Arundel C of E Primary School
Jarvis Road
Arundel
West Sussex
BN18 9HT

Please ask for: Mrs D Johnson
Email: daun.johnson@arun.gov.uk
Telephone: 01903 737762
Our Ref: AB/81/20/PL
Your Ref: Mrs Tipton
Date: 28th July 2020

Application for Planning Permission

Development: Siting of a modular building to use as a pre-school nursery.
Location: Arundel Church Of England Primary School Jarvis Road Arundel BN18 9HT

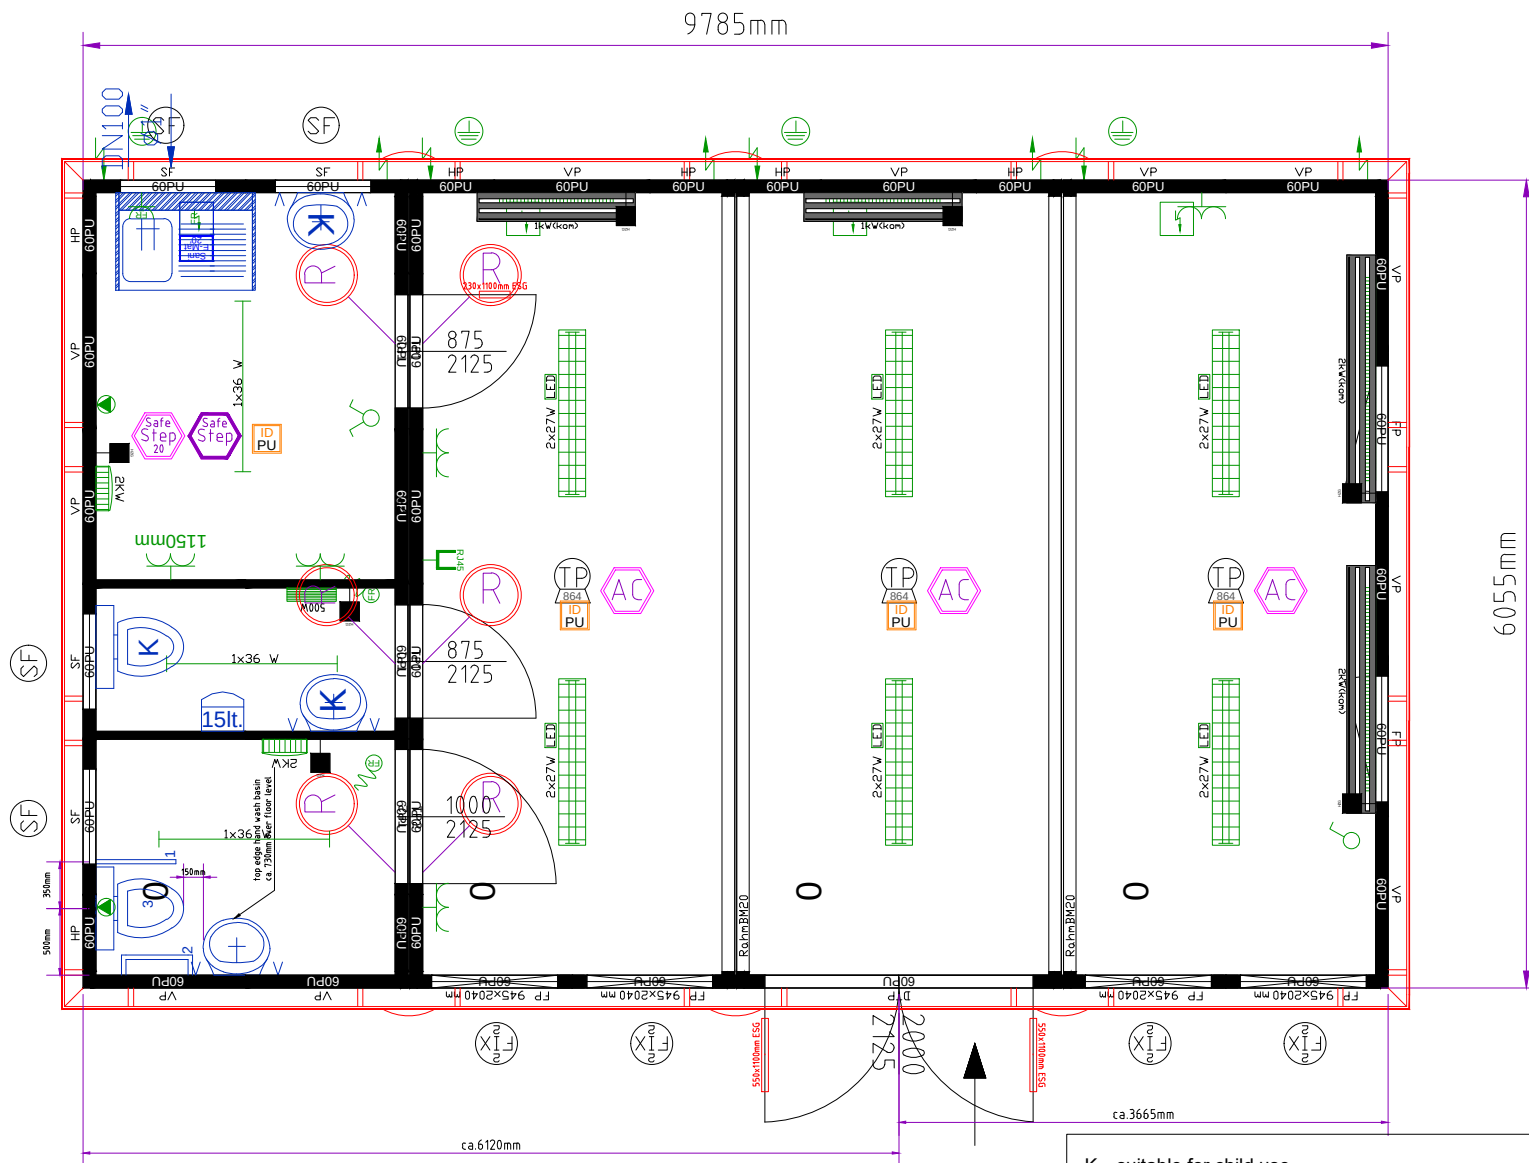
On the proposed elevations, please provide a scale or measurements, in metric.

Arundel CofE Primary School Map 1 Whole site

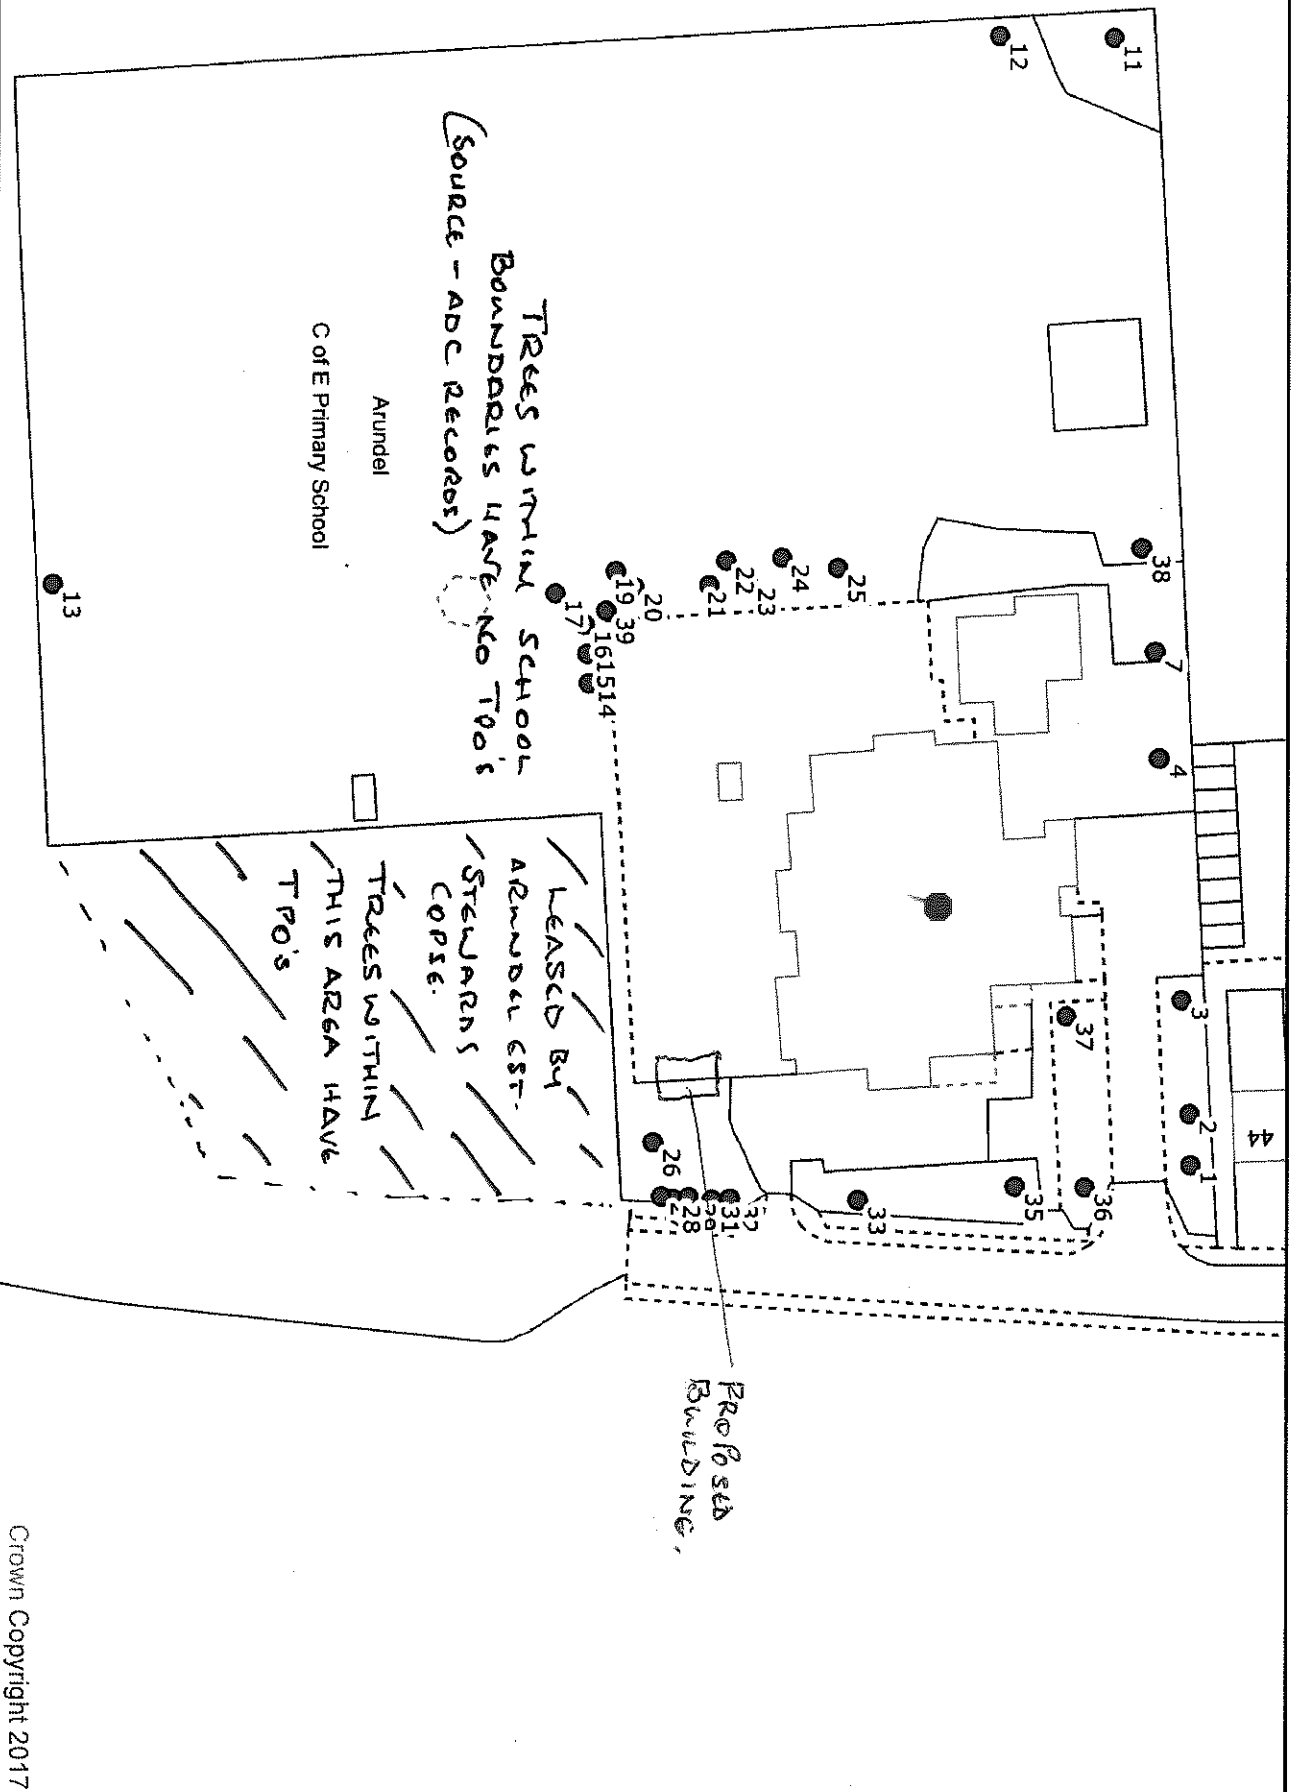
On the location plan, please red edge the site.

PROPOSED MODULAR BUILDING
FOUL WATER. (PROPOSED)
WATER SUPPLY
ELECTRIC SUPPLY
RAINWATER F/W DRAINS
EXISTING

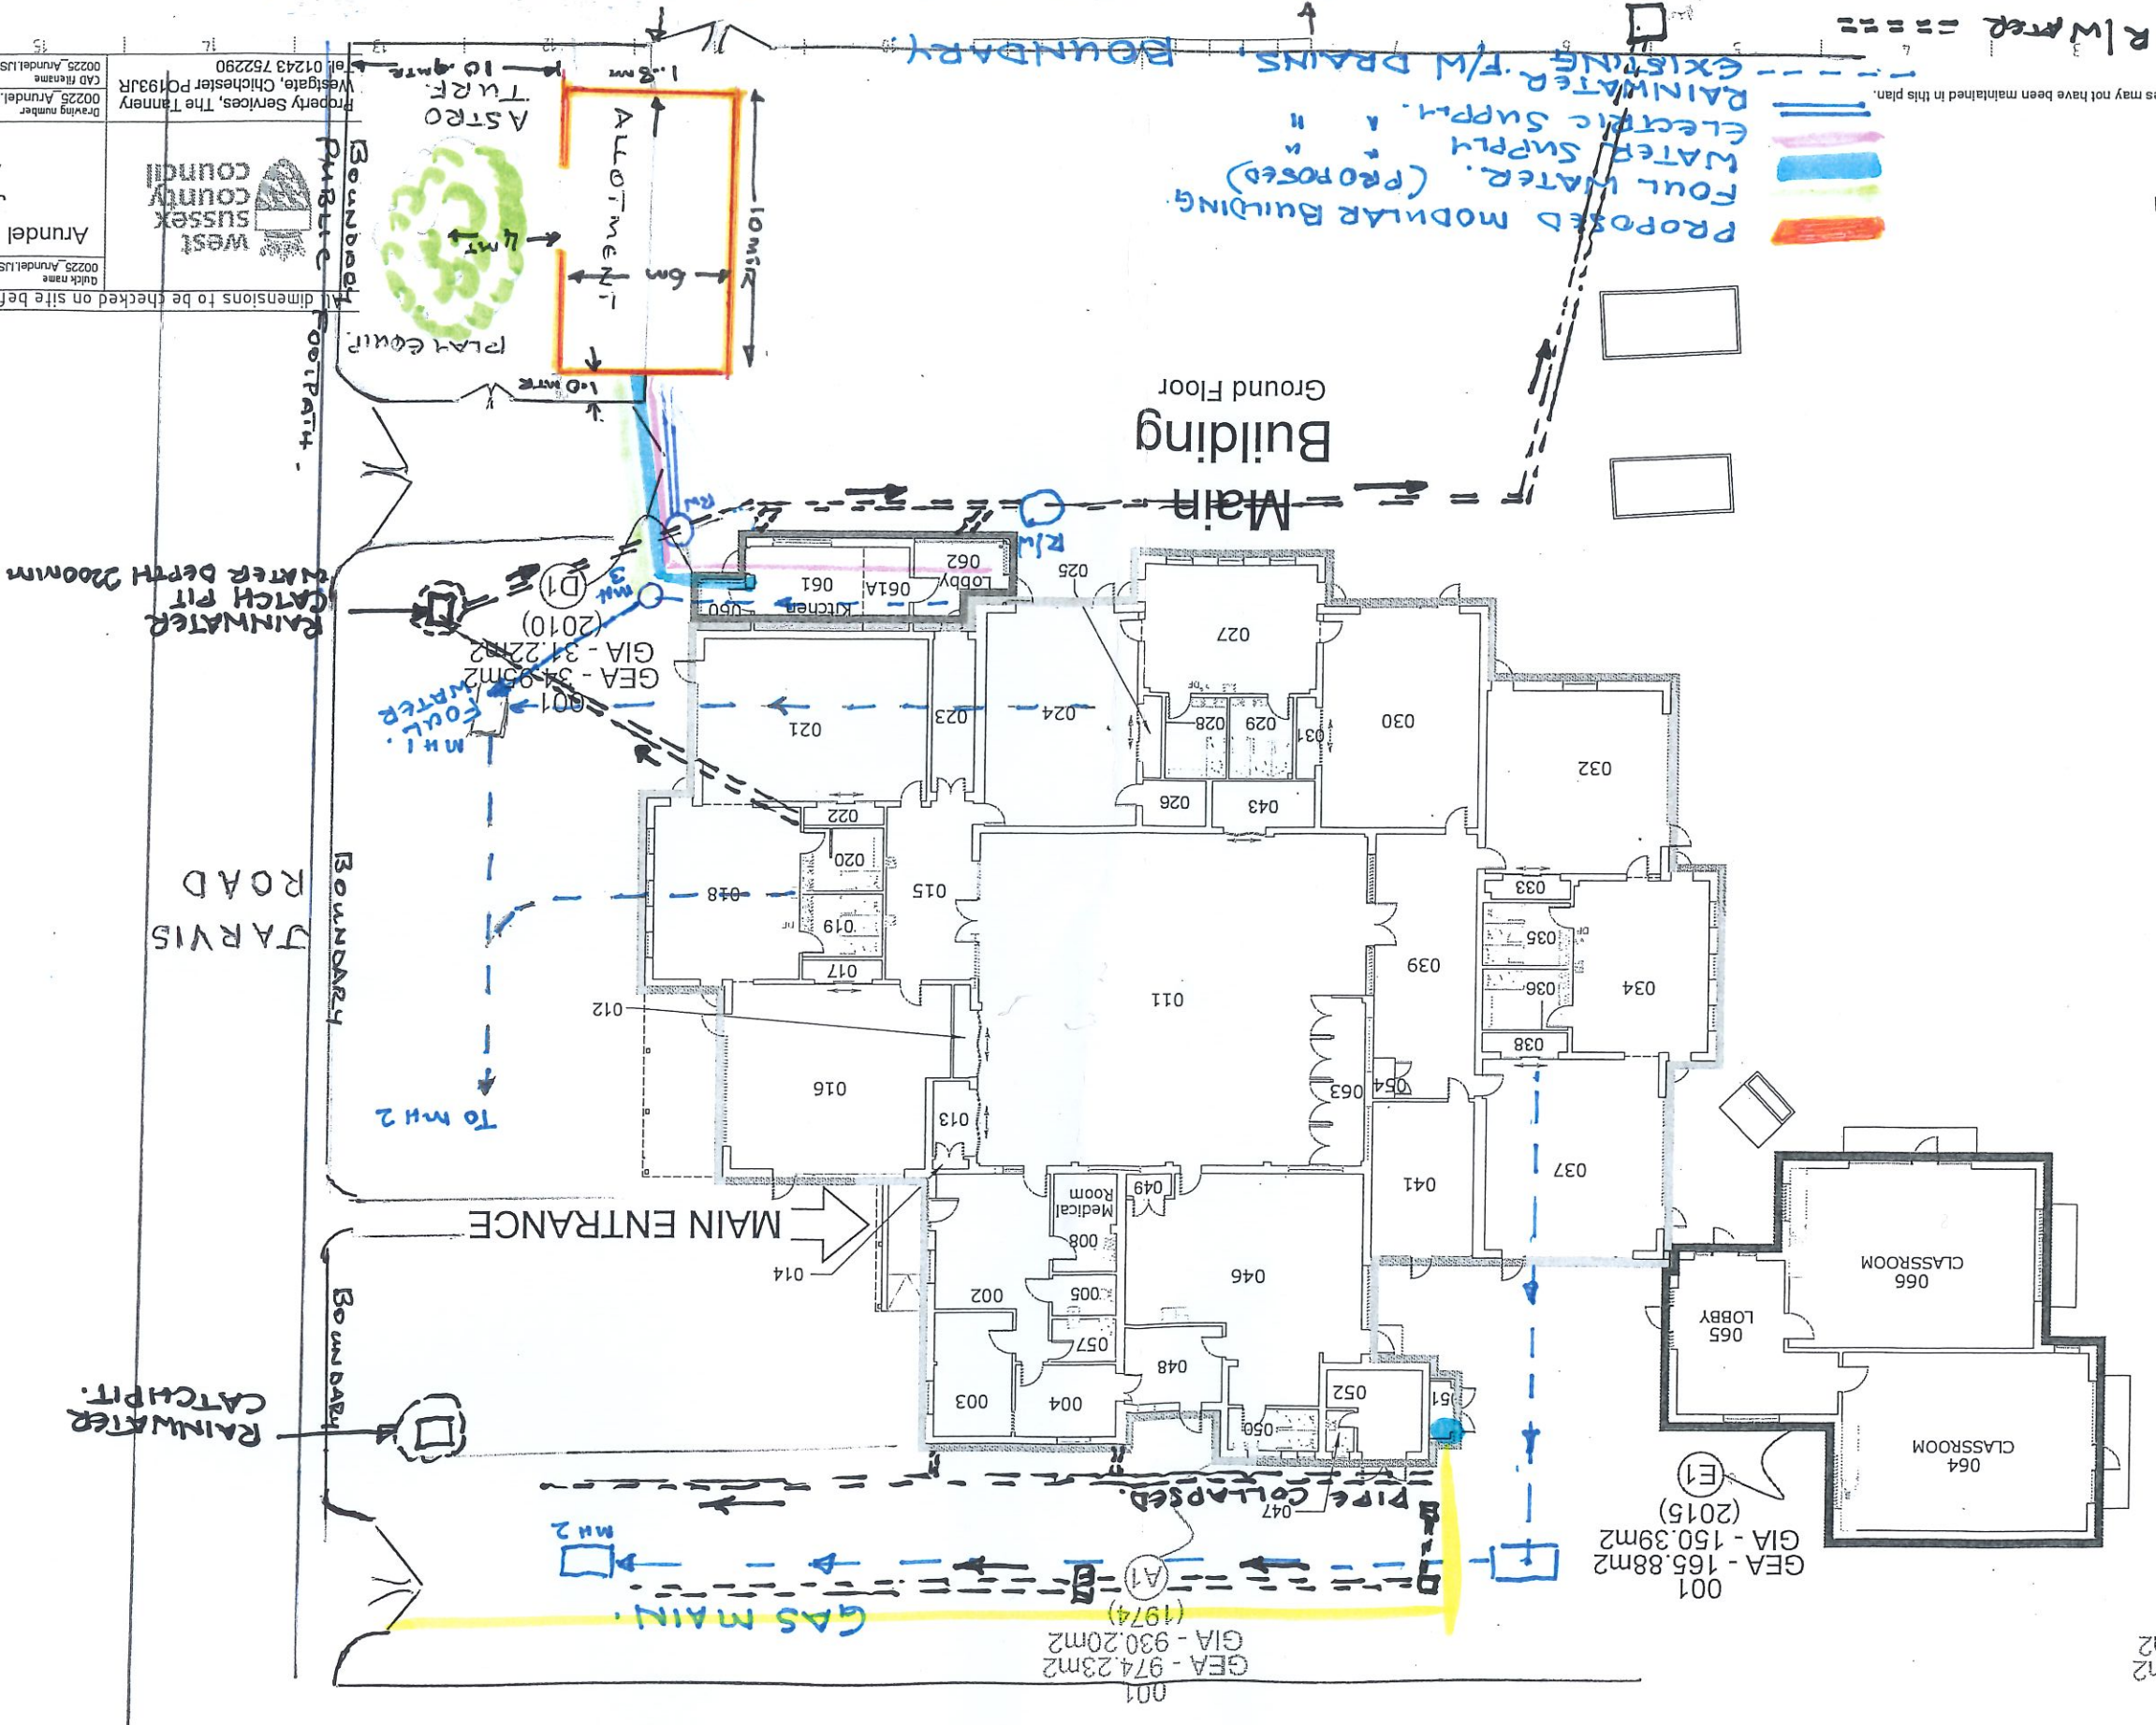
On the block plan, clearly show the position of the modular building.
